About the application

Application number: 2025/93140	
What is the application for?:	Installation of replacement shop front and roller shutter (within a Conservation
Address of the site or building:	Kami Healthcare Ltd, 8, Market Place, Birstall, Batley, WF17 9EL
Postcode:	WF17 9EL

Proposed Front Elevation with Roller Shutter

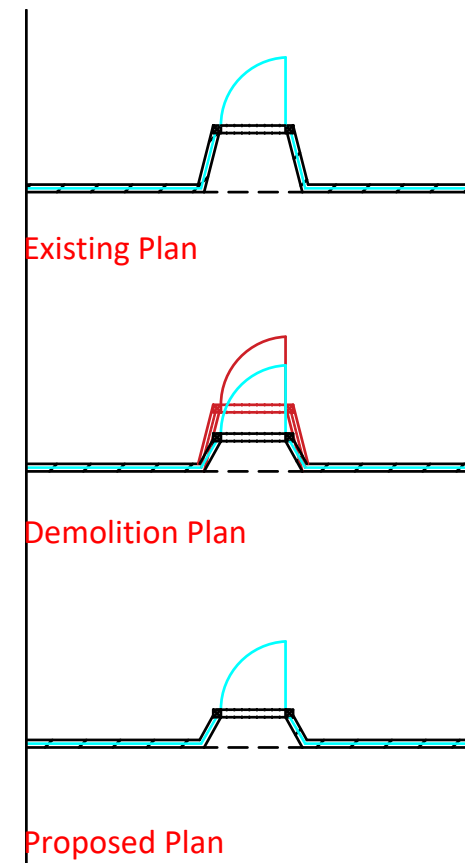
Type of comment: An objection	
Do you wish your comments to be published on the website anonymously?	Yes
<p>I object to the roller shutter being installed. The properties either side do not appear to have shutters and this would adversely affect the character and appearance of this row of buildings within a conservation area. The premises are directly opposite the market square, the focal point of the village.</p> <p>I also note a Barbers is proposed for this building. Birstall currently has 5 Barber shops within the village centre, with one already opening 7 days per week, and another 3 within a 5min walk from the centre. Birstall is saturated with Barbers, this makes the village unattractive to new investors when there are so many businesses offering the same thing, a lack of retail diversity will deter people from spending money in the area.</p>
